# CITY OF ALBUQUERQUE

October 9, 2012

**Re: Amendment to the Trails Drainage Master Plan  
Engineer's Stamp Date 9-7-12 (C09-D001)**

Based upon the information provided in your submittal received 9-7-12, the above referenced report cannot be approved until the following comments are addressed:

C09-D001
THE TRAILS Units 1-3
Amended D M P
Drainage Management Plan
April 2014
- Composite of Plates 1 & 2 -

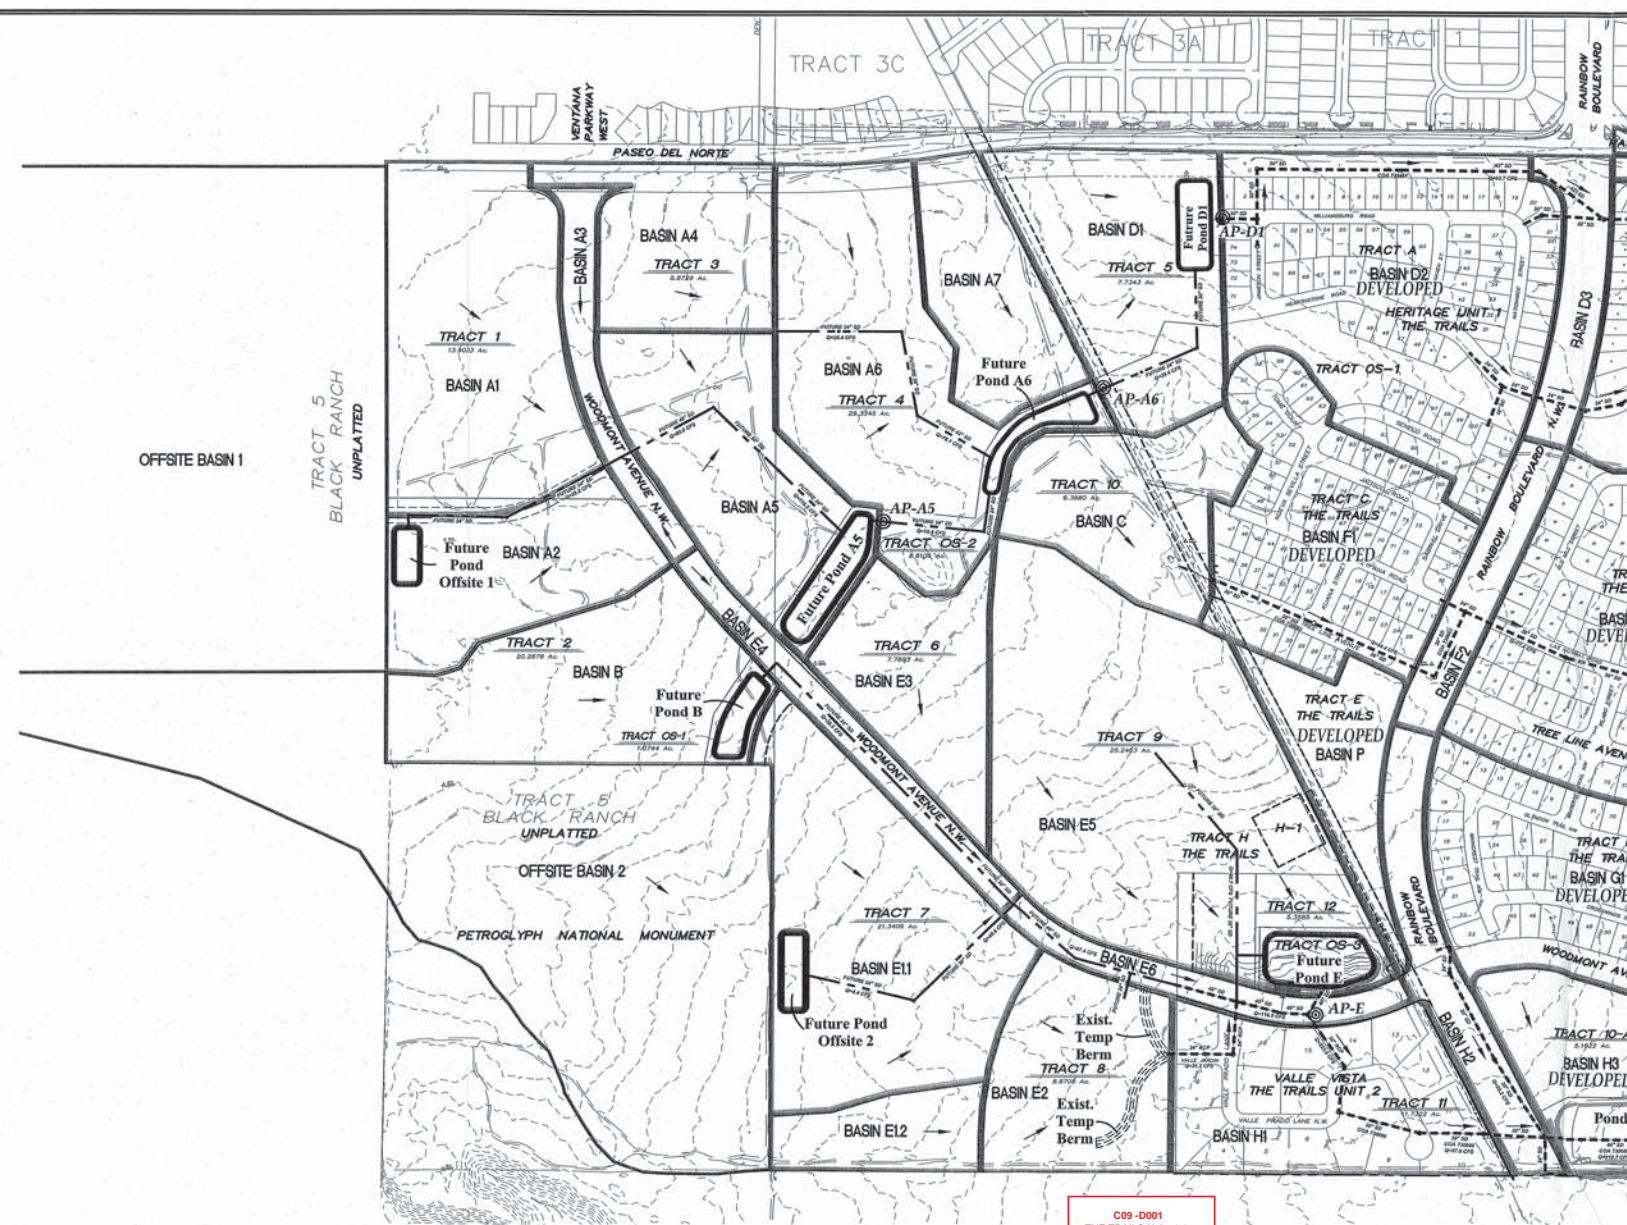
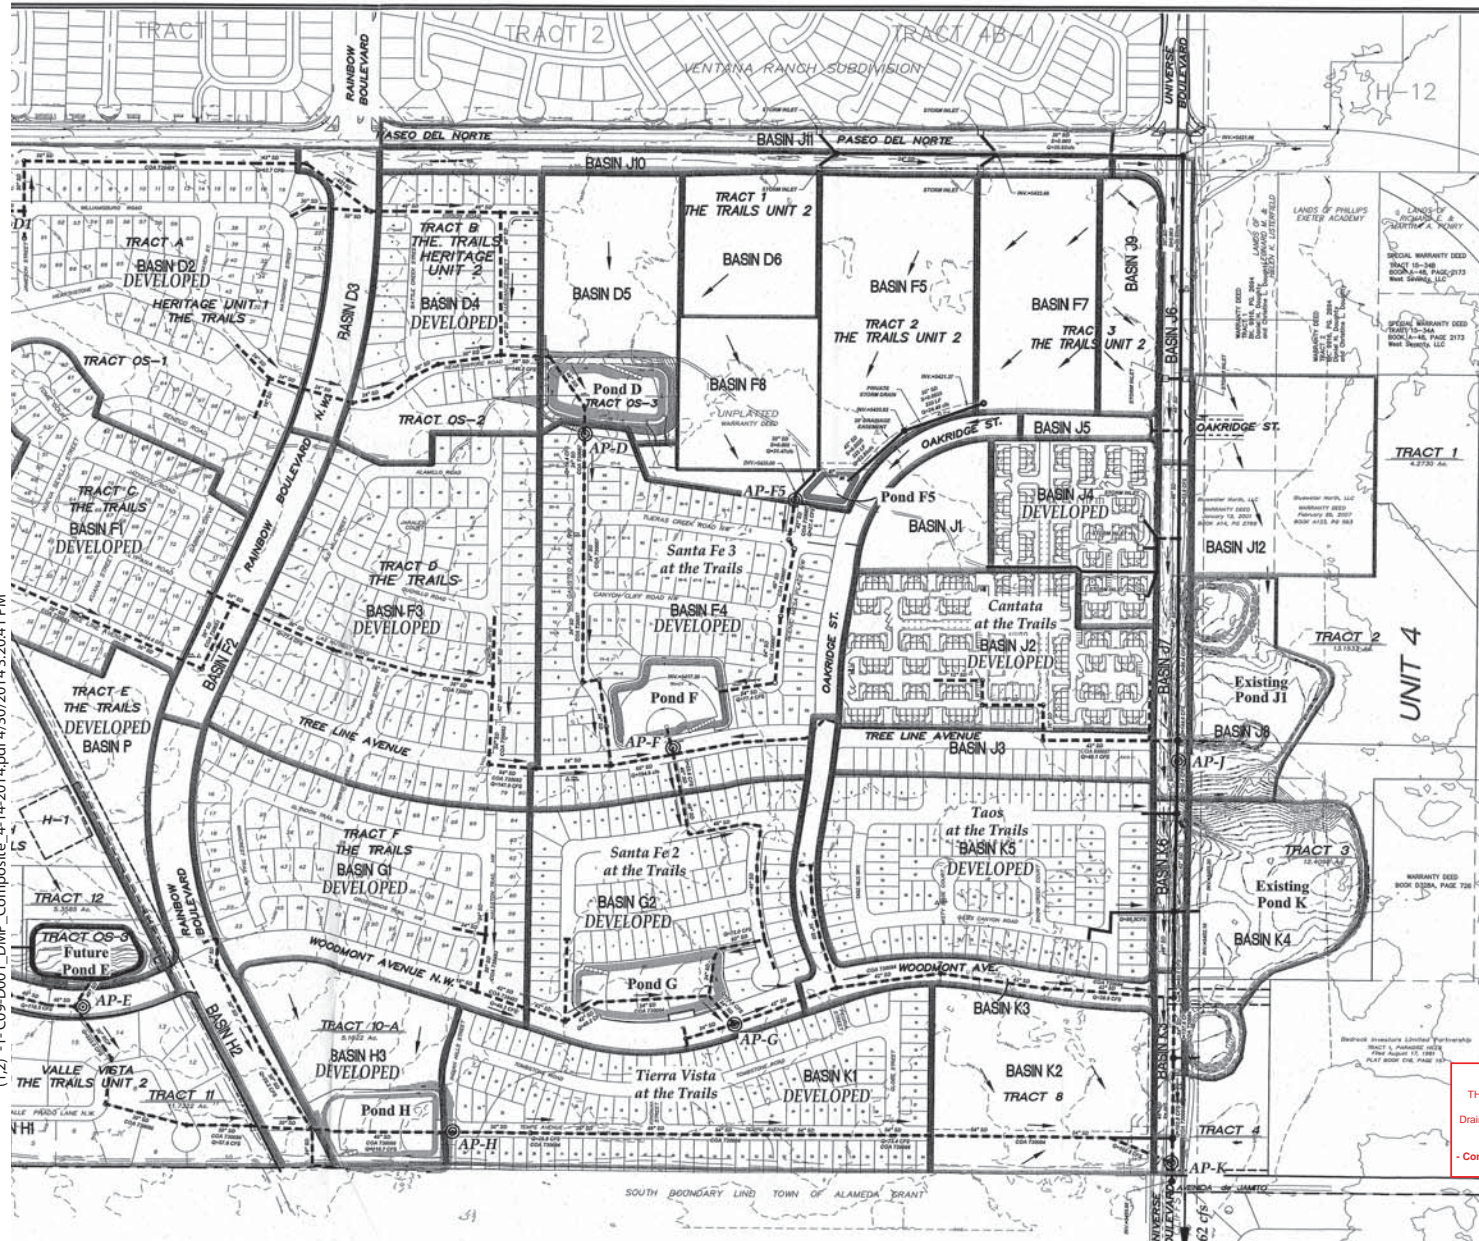
3. Analysis Point AP-D is shown to have a peak flow of 9.15 cfs. The as-builts show a flow of 24 cfs. With pressure flow, shouldn't this pipe be carrying closer to 35 cfs? If an orifice plate is proposed, it should be shown on the plate and discussed in the report.

8. Why was the 24-hour storm used for peak flows, when the 6-hour storm produces a higher peak? Provide an HGL for the Universe Blvd storm drain using the 6 hr storm. The flow values for the storm drains shown on the plates should be the 6 hour storm values rather than the 24 hour storm. Pond volumes and WSE's should use be the 24 hour storm if it takes longer than 6 hours for them to drain.

9. Provide pond hydrographs so the drain time is known.
10. The storm drain in Rio Glister Pl is shown as 24" on Plate 2, but is a 30" on the CPN 730087 as-builts. Provide as-builts for all storm drains at The Trails, so storm drains in the proposed DMP can be verified.

14. Since there is no Pond L, would it be clearer to rename the "L" basins to "J"?
15. Are ponds Pond Offsite 2, Pond Offsite 1, Pond B, Pond A5, Pond A6 Pond D1 and Pond E constructed? If not, please label them as future ponds.

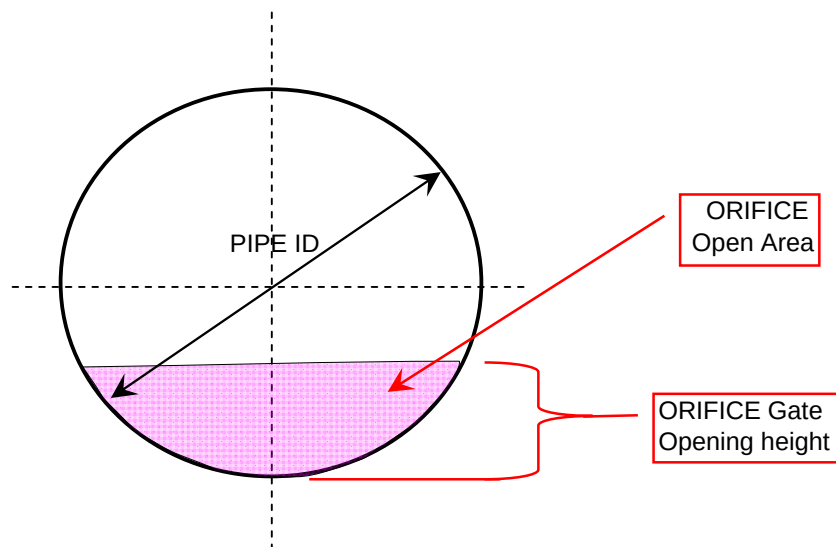
4. Why is the outflow from Pond G only 7 cfs? Similar to Pond D, a 24" storm drain with 6 feet of head should have a higher flow.
5. Hydrology is concerned with the use of orifice plates as they may plug and unlike a standpipe, the debris/sediment cannot be easily detected. What is the smallest orifice that should be built in a storm drain before it will get plugged with debris? 8 inches? 12 inches?

6. What is the required volume of Pond K if orifice plates are not installed?
7. In surge ponds D, G and H the invert is lower than the bottom of pond. The flow values appear to be low.
